Rezoning Transportation Analysis

Petition Number: #2022-099

Revision Log:

Date	Description
11-28-22	First Review (IW)
12-22-22	Second Review (IW)

**RZ-1**

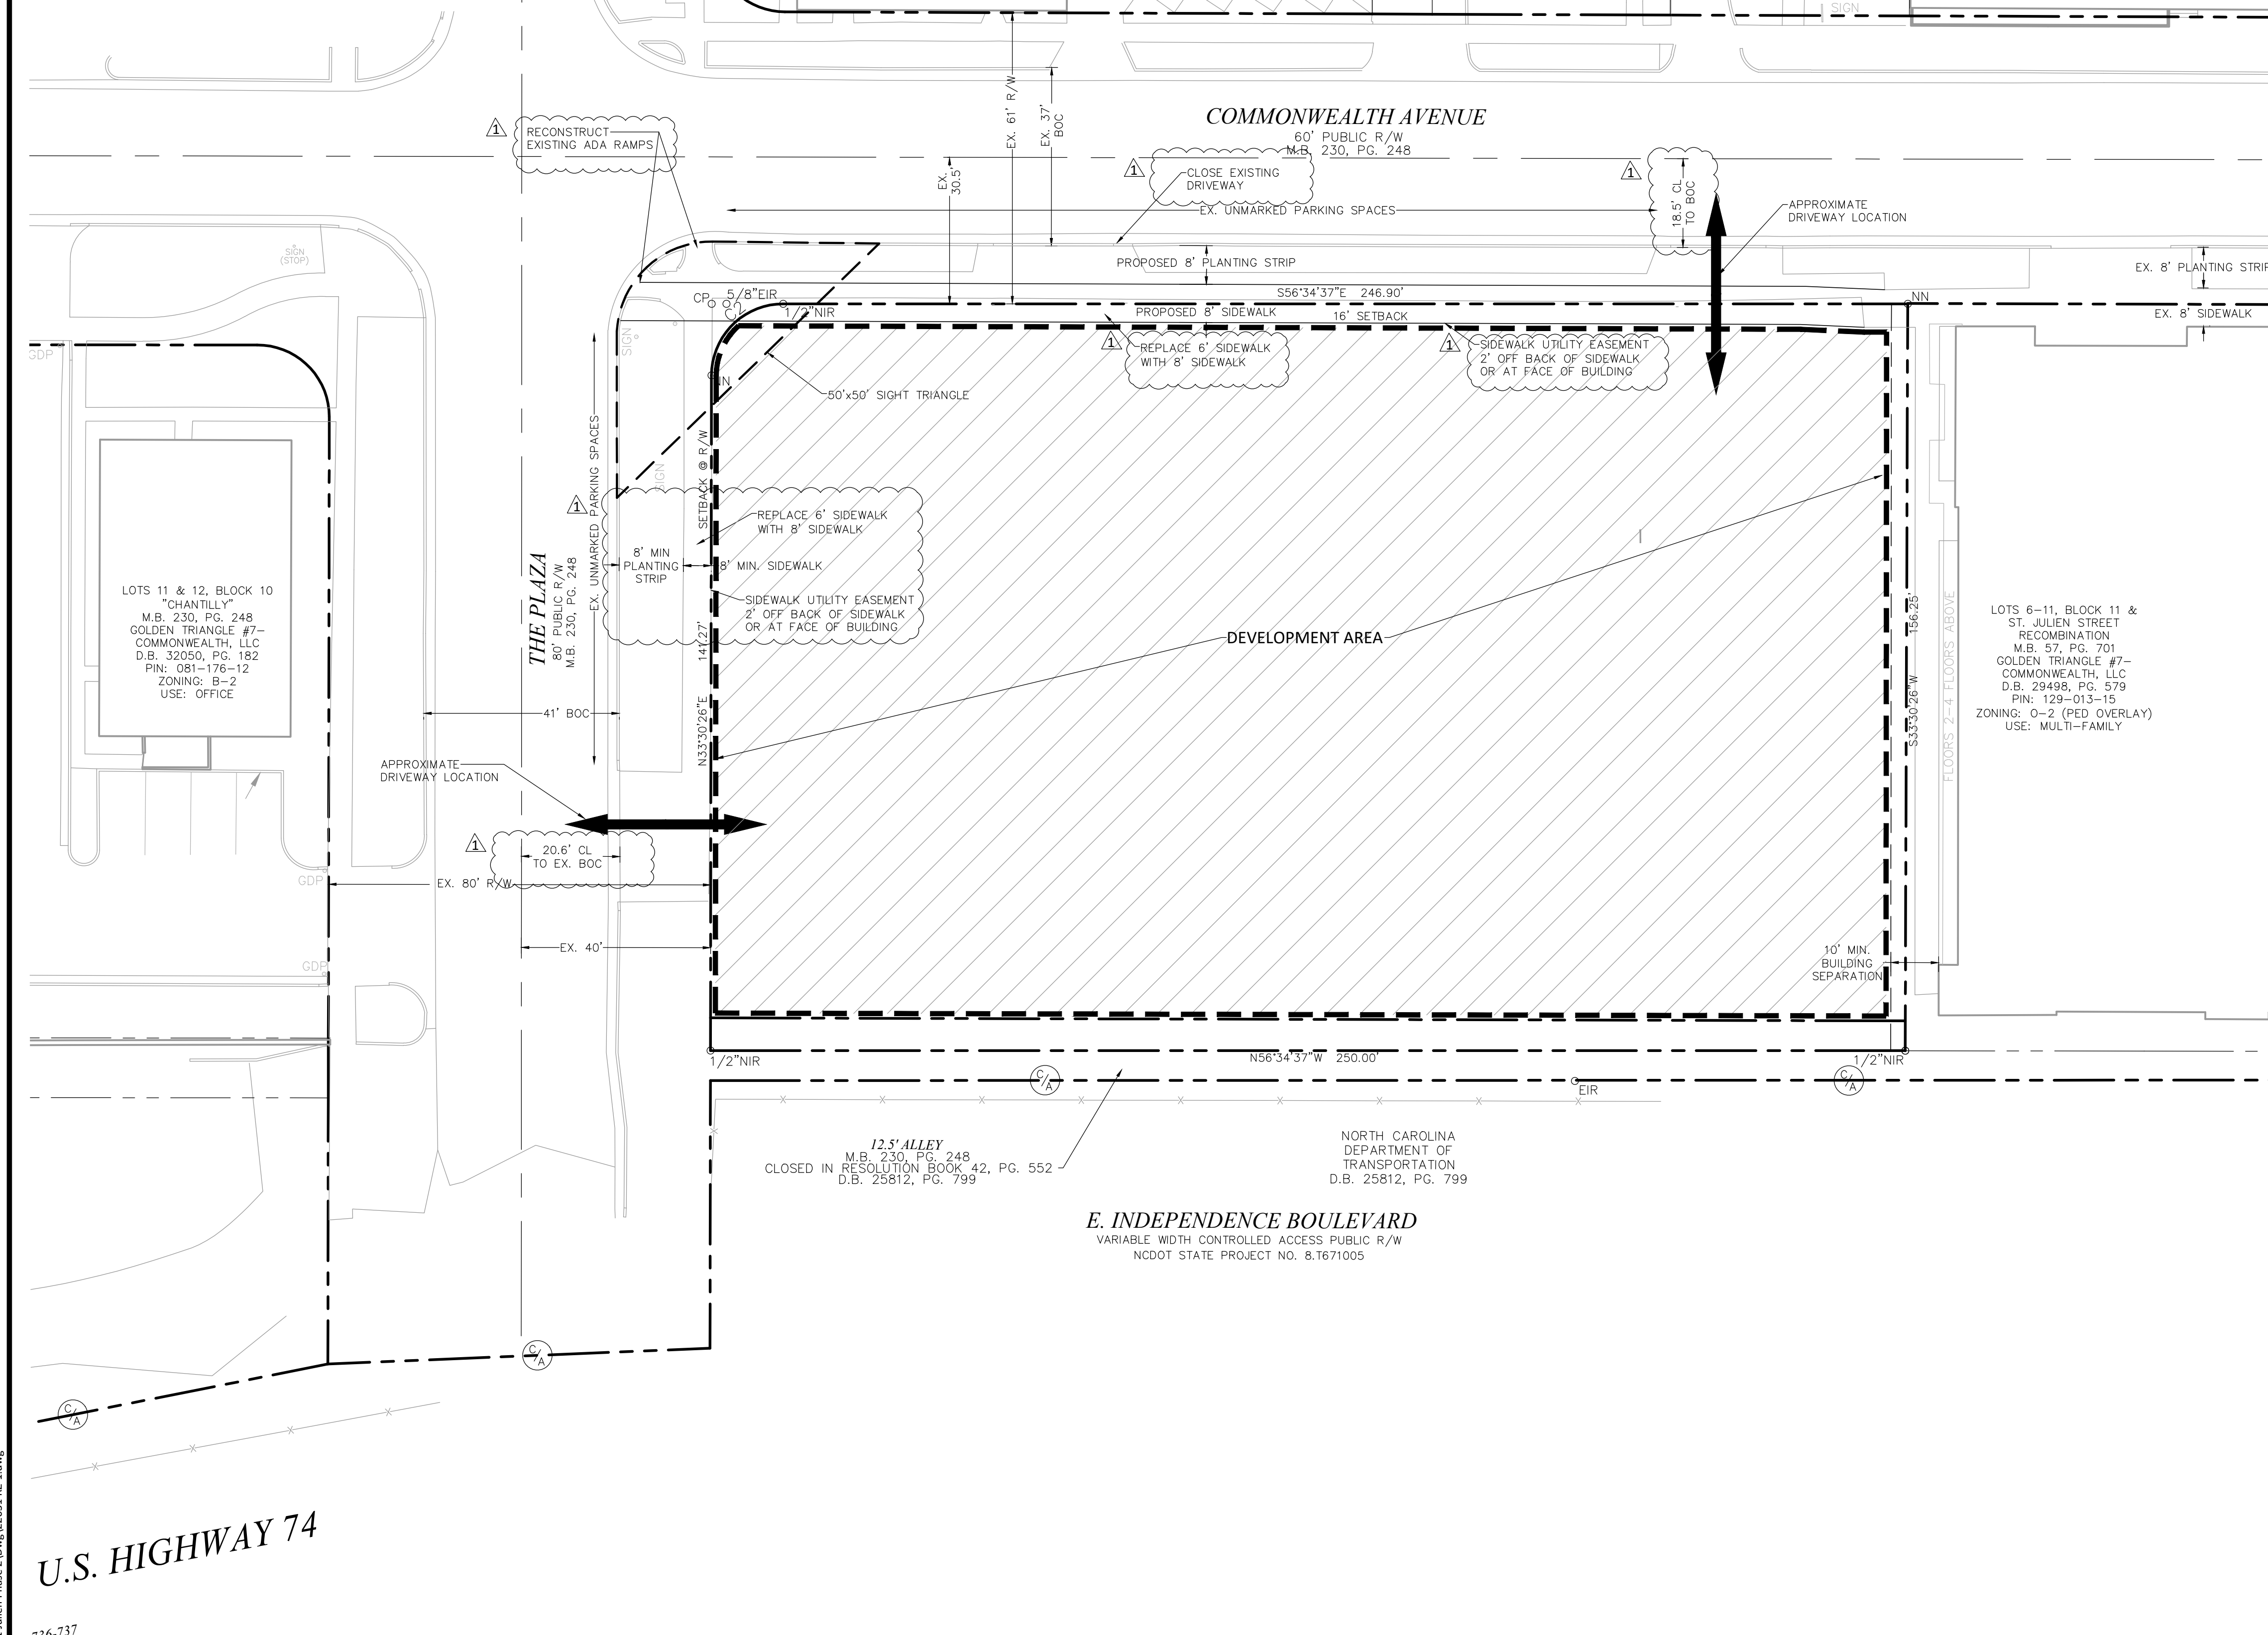
3. **Outstanding Comment from 11-28-22: Comprehensive Transportation Review (CTR):**

The Comprehensive Transportation Review was recently approved by City Council under the new UDO. In lieu of a TTM for the proposed site CDOT has requested the petitioner complete a CTR for the site. The petition's zoning falls within the medium to high intensity development which based on the 1,775 daily trips will trigger Tier 3 (14 mitigation points) for multimodal assessment and Tier 3 (6 mitigation points) for transportation demand management assessment.

The petitioner shall review and assess the publicly accessible pedestrian network within ¼ mile walking distance of the site to identify multimodal infrastructure to meet the Tier 3 (14 mitigation points) for multimodal assessment. Petitioner shall also provide transportation demand management strategies to meet Tier 3 (6 mitigation points) to reduce vehicle trips and encourage alternative modes of transportation.
